**CITY OF ALBUQUERQUE
PLANNING DEPARTMENT
HYDROLOGY DEVELOPMENT SECTION**

DEVELOPMENT REVIEW BOARD--SPEED MEMO

DRB CASE NO/PROJECT NO: 1007343

RE: Lot 9, Blk 4, Tr C, Unit 3, North Albuquerque Acres

ACCC Building Permit

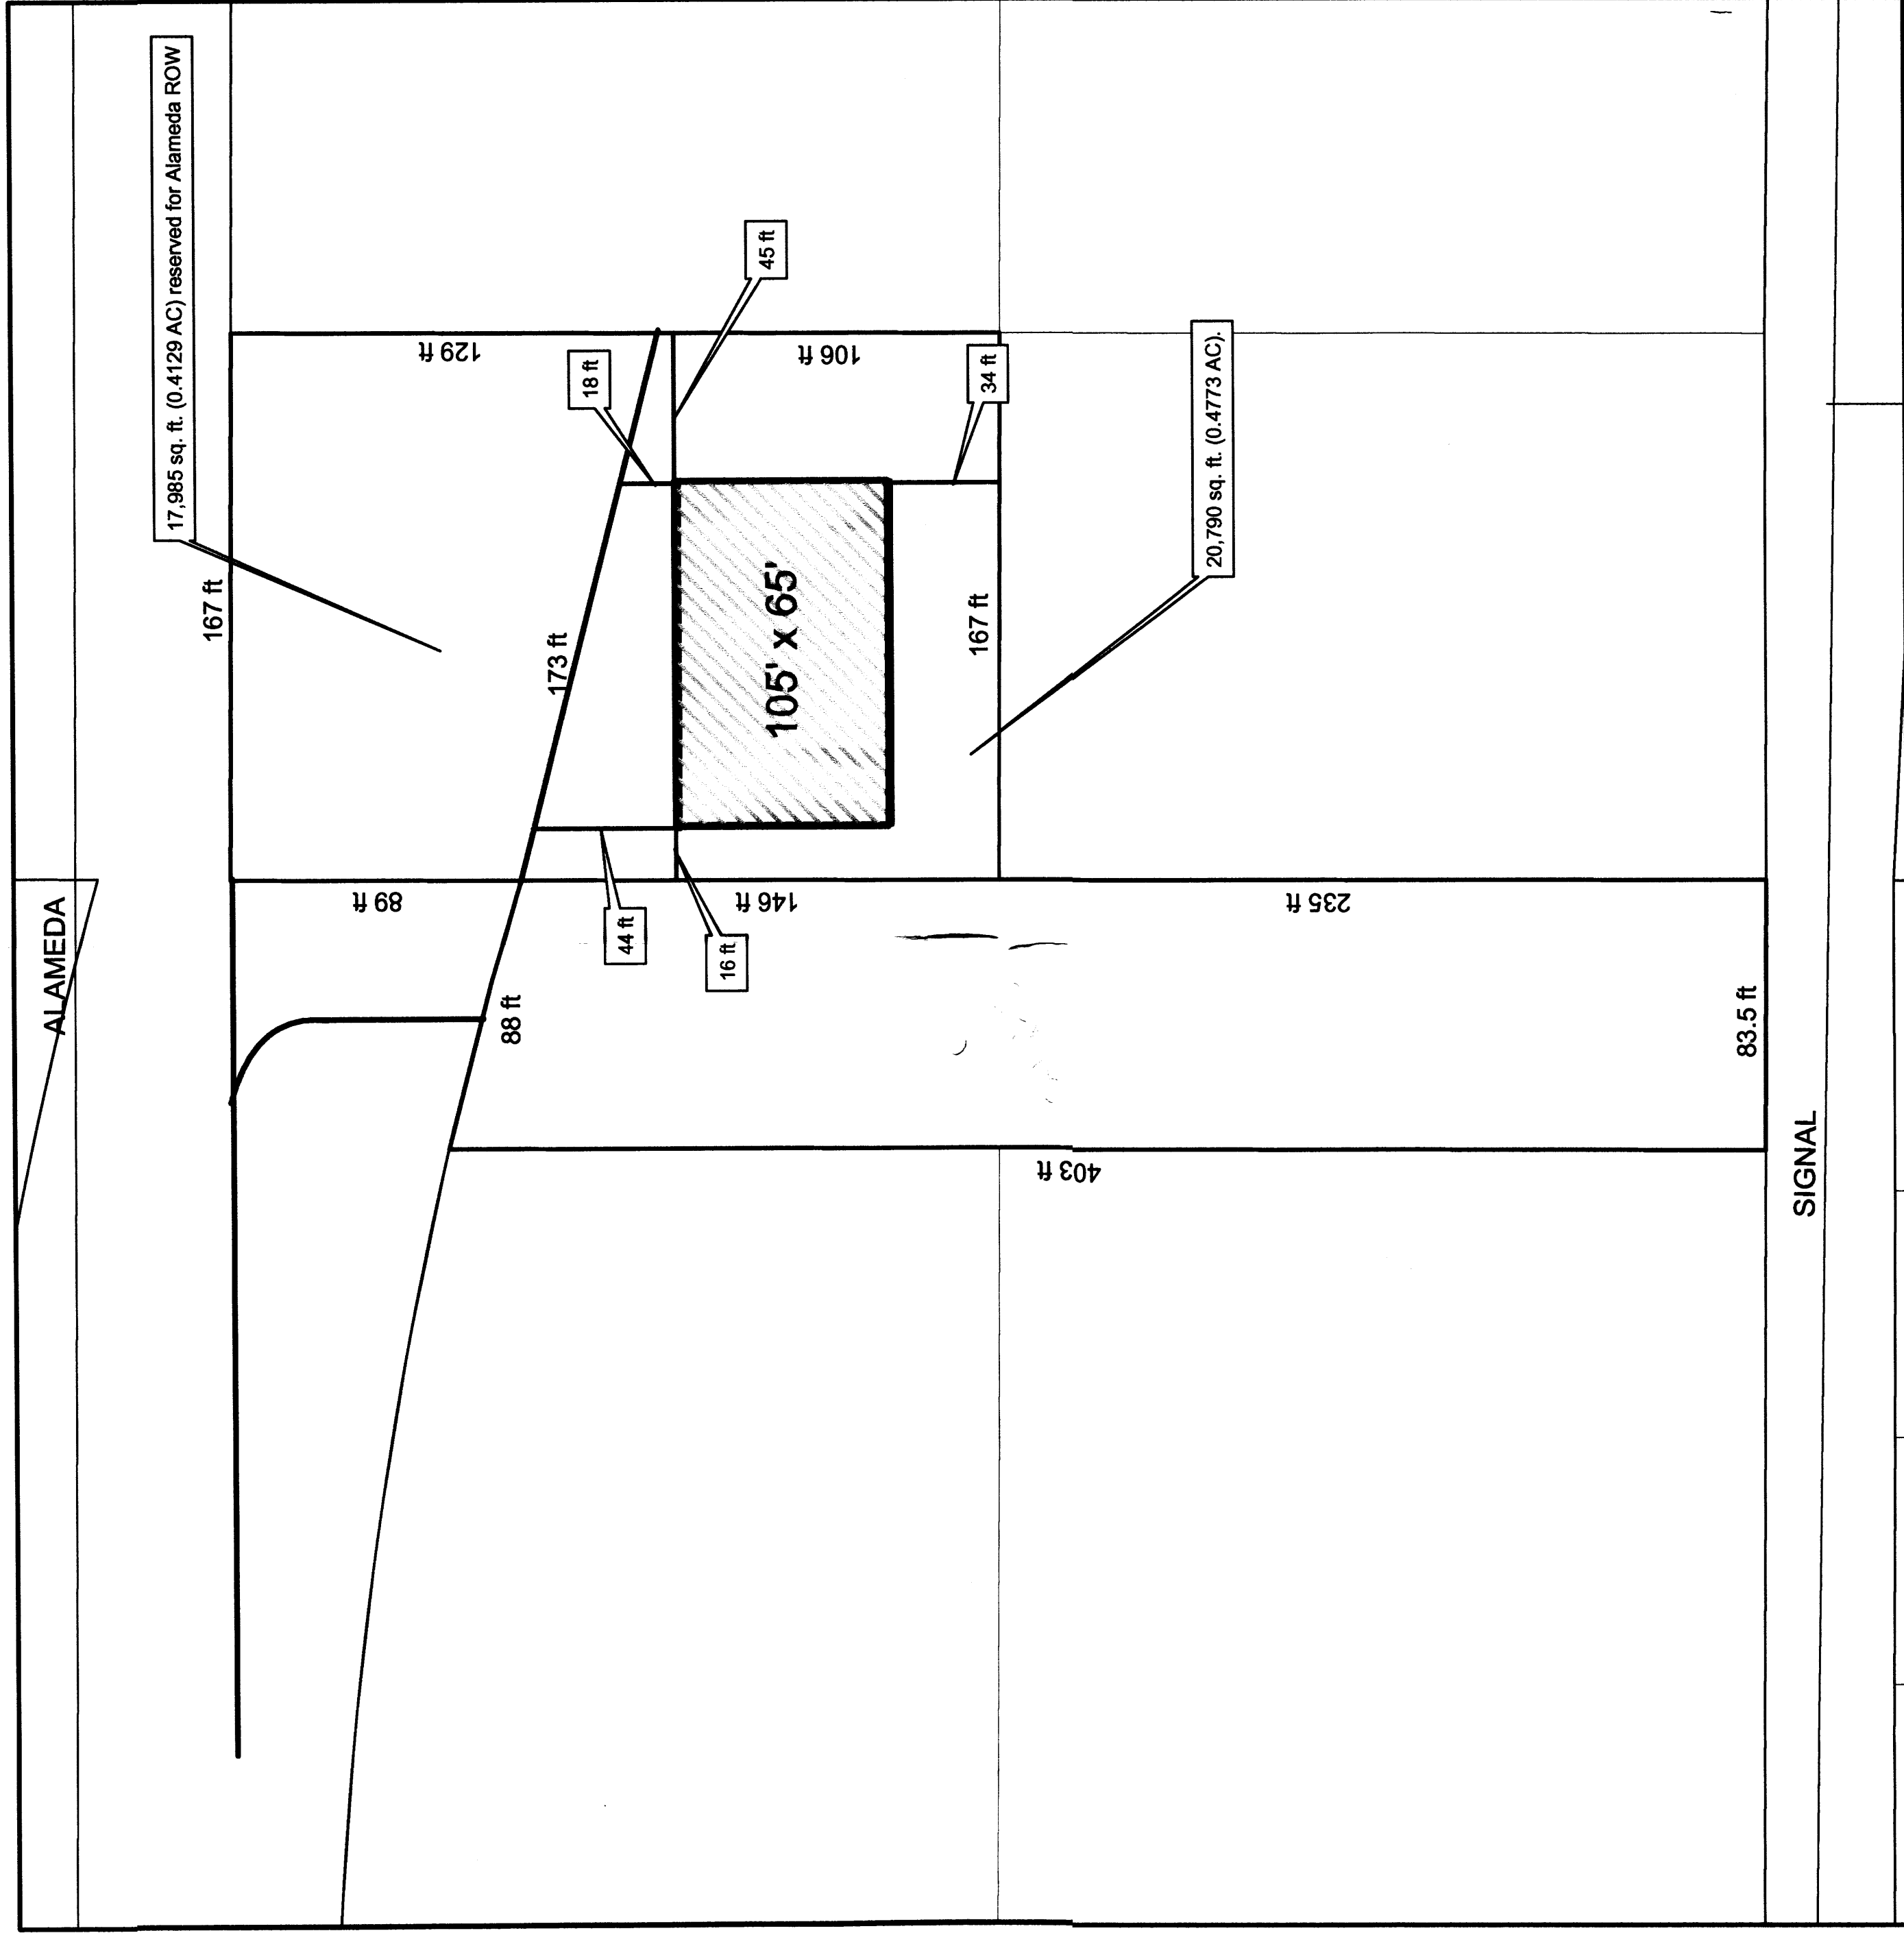
Property is within floodplain. Must adhere to City Flood Hazard Ordinance.

Lot C is shown on the site plan for Hope Plaza to be mostly floodplain, with a significant berm constructed for flood control. Lot 9 is zoned R-D and within the La Cueva Sector Development Plan – only residential use is allowed. Lot C is shown on the site plan for Hope Plaza to be mostly floodplain, with a significant berm constructed for flood control.
